COUNTY OF HARNETT LAND USE APPLICATION
Central Permitting 108 E. Front Street, Lillington, NC 27546 Phone: (910) 893-7525 Fax: (910) 893-2793 www.harnett.org

PROPERTY LOCATION: Subdivision: Tingen Pointe Lot #: 25 Lot Size: .345 AC

PRELIMINARY SITE PLAN FOR:
WYNN CONSTRUCTION

RE: Harnett County Land Use Application HTE 07-5-18610 Tingen Pointe Lt 25

PRELIMINARY SITE PLAN FOR:

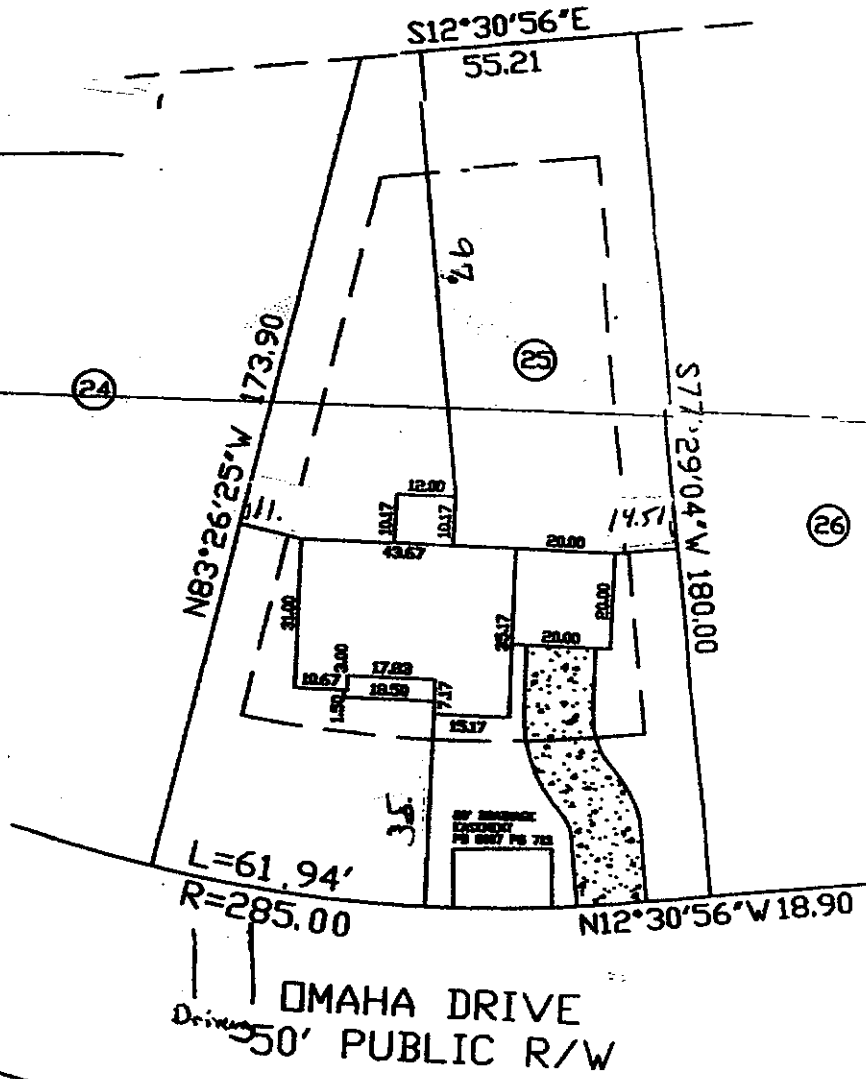
- 1. Property lines/corners not marked or labeled
- 2. House corners not marked or labeled
- 3. Directions not clear to property
- 4. Property needs brush or vegetation removed
- 5. Backhoe pits required
- 6. Other Move house as shown on attached sheet. Submit new plot plans to Central Permitting.
